**EL PASO COUNTY PLANNING AND
 COMMUNITY DEVELOPMENT
 DEPARTMENT**

Engineering Review

12/16/2019 2:24:08 PM

STORMWATER MANAGEMENT PLAN CHECKLIST

ELDORADO SPRINGS	DESIGNED BY: MGP	DRAWN BY: MGP
	SCALE: N/A	DATE: 05/05/20
GRADING & EROSION CONTROL DETAILS	JOB NUMBER: 91807	SHEET: GR4 OF 8

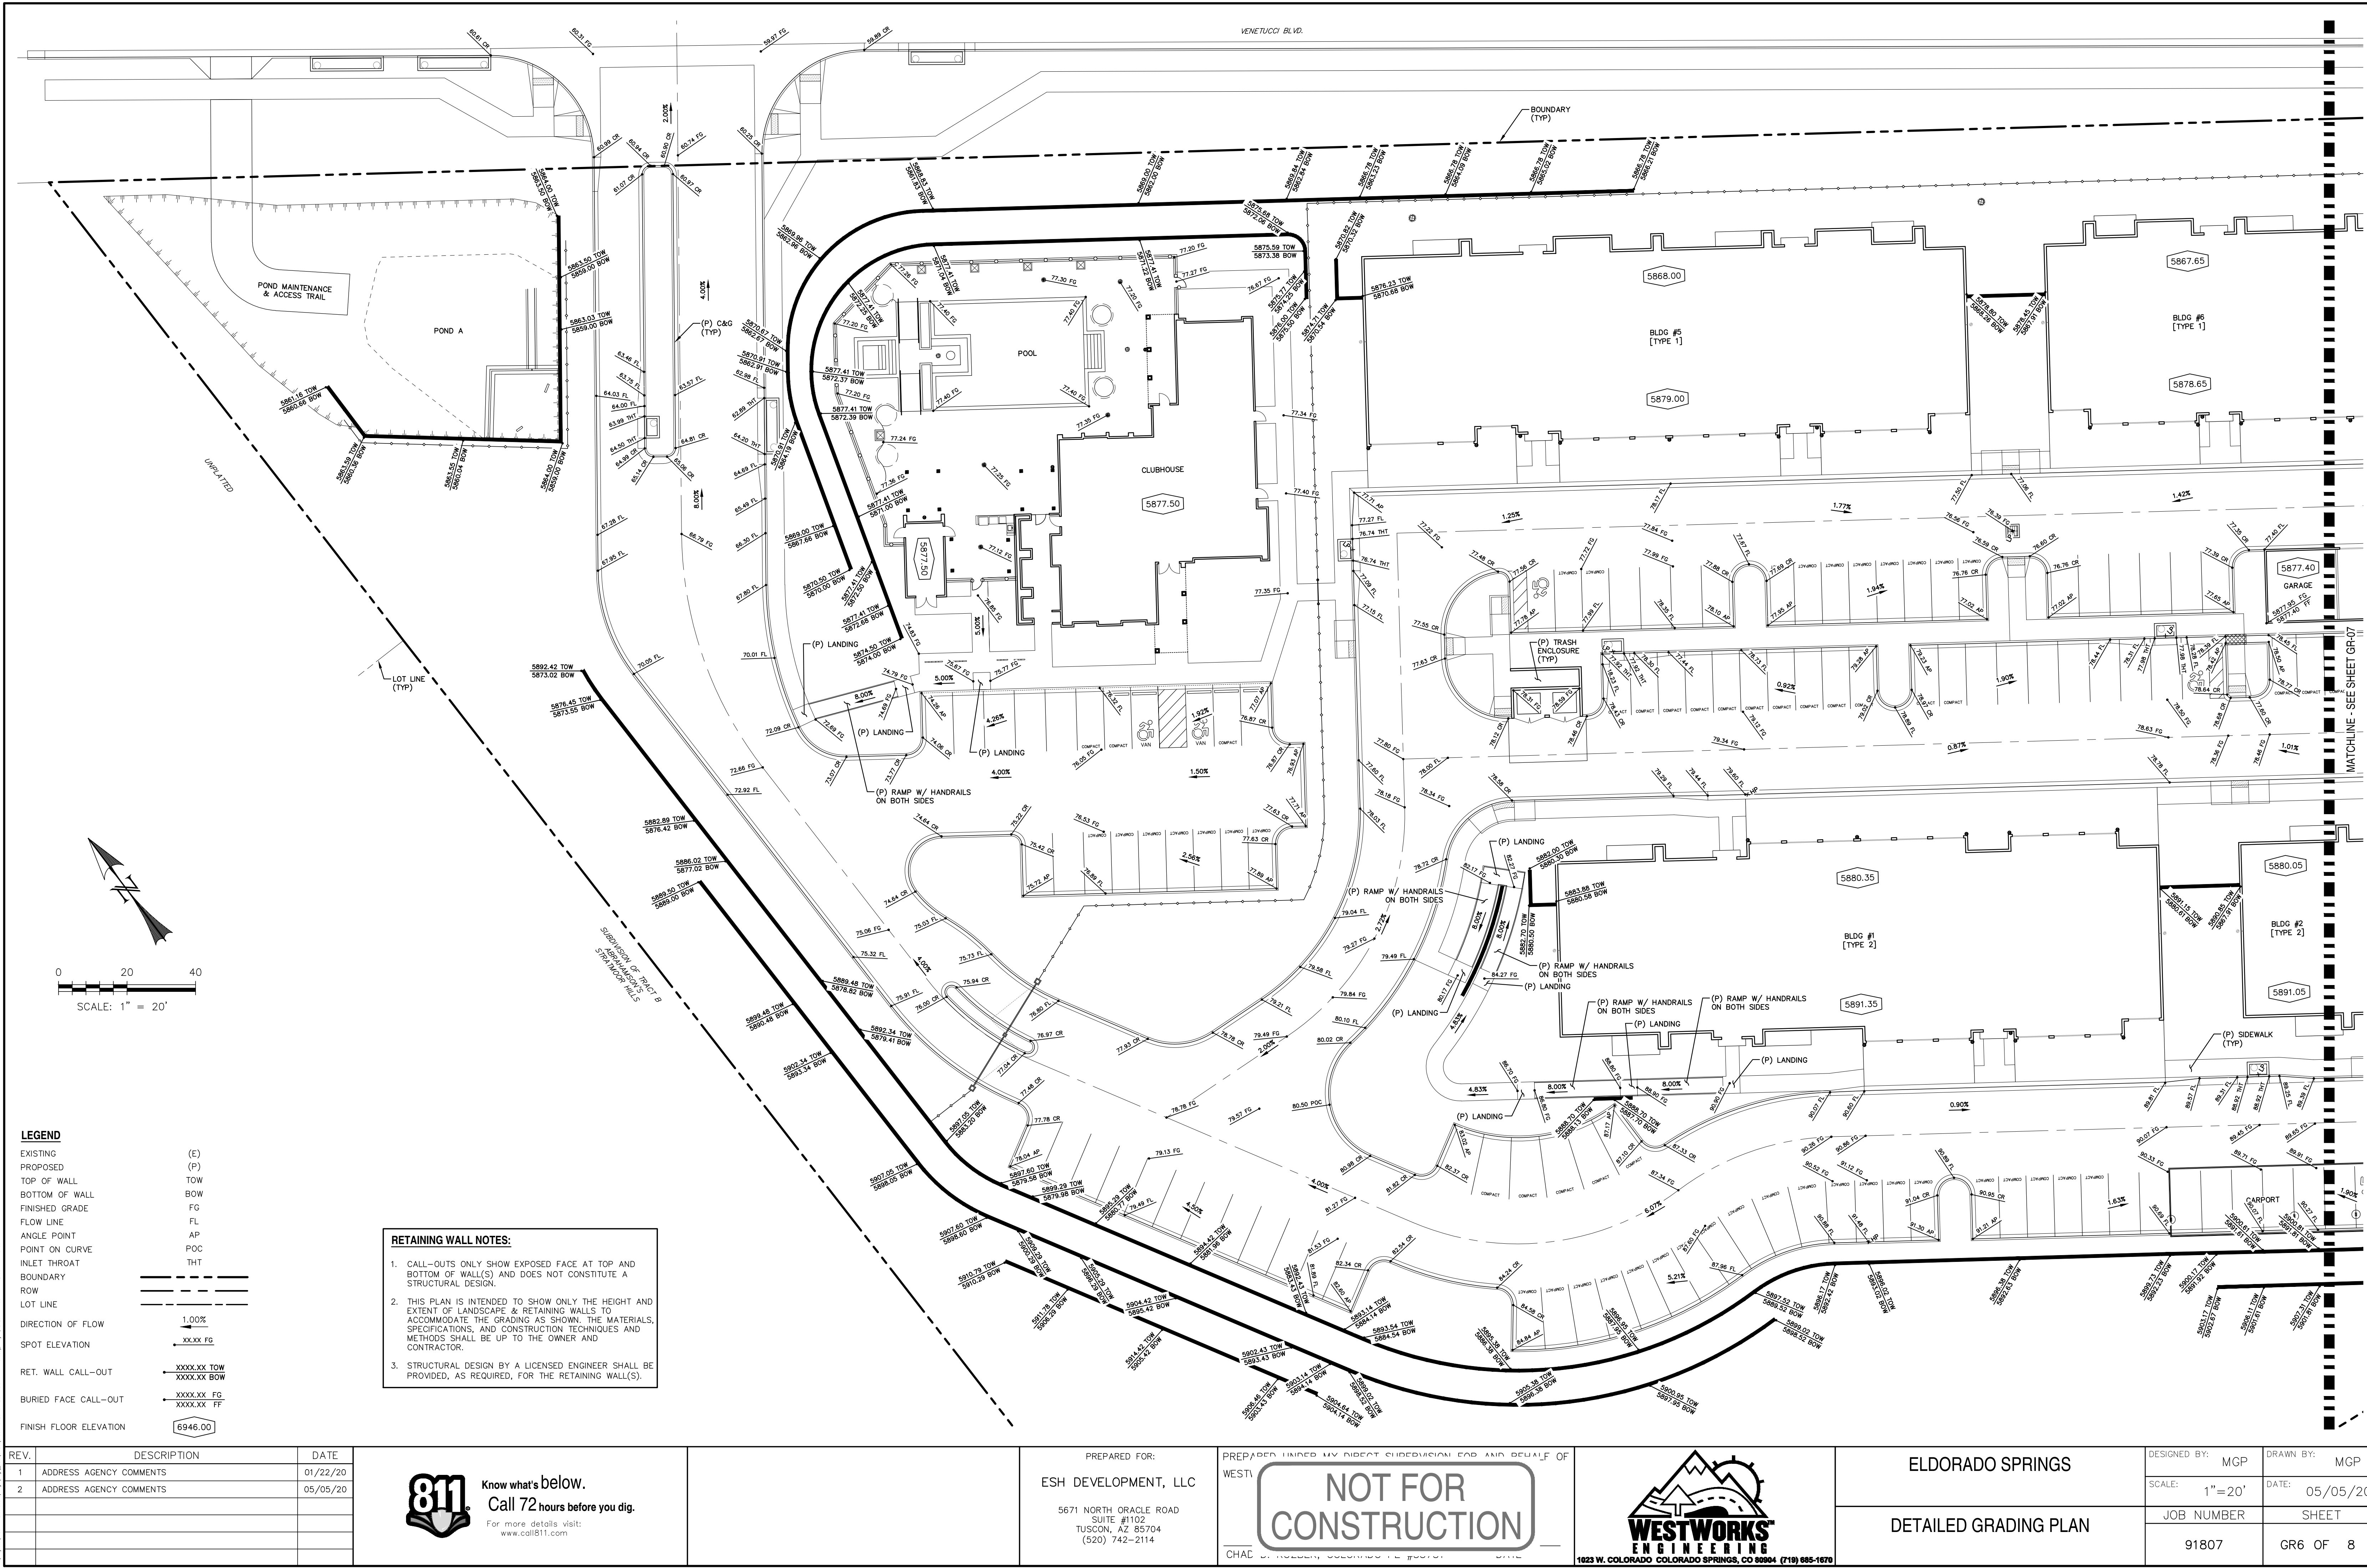
Existing contours not
 labeled.

Call out Areas of
 Disturbance note
 comment on the GEC
 Plan.
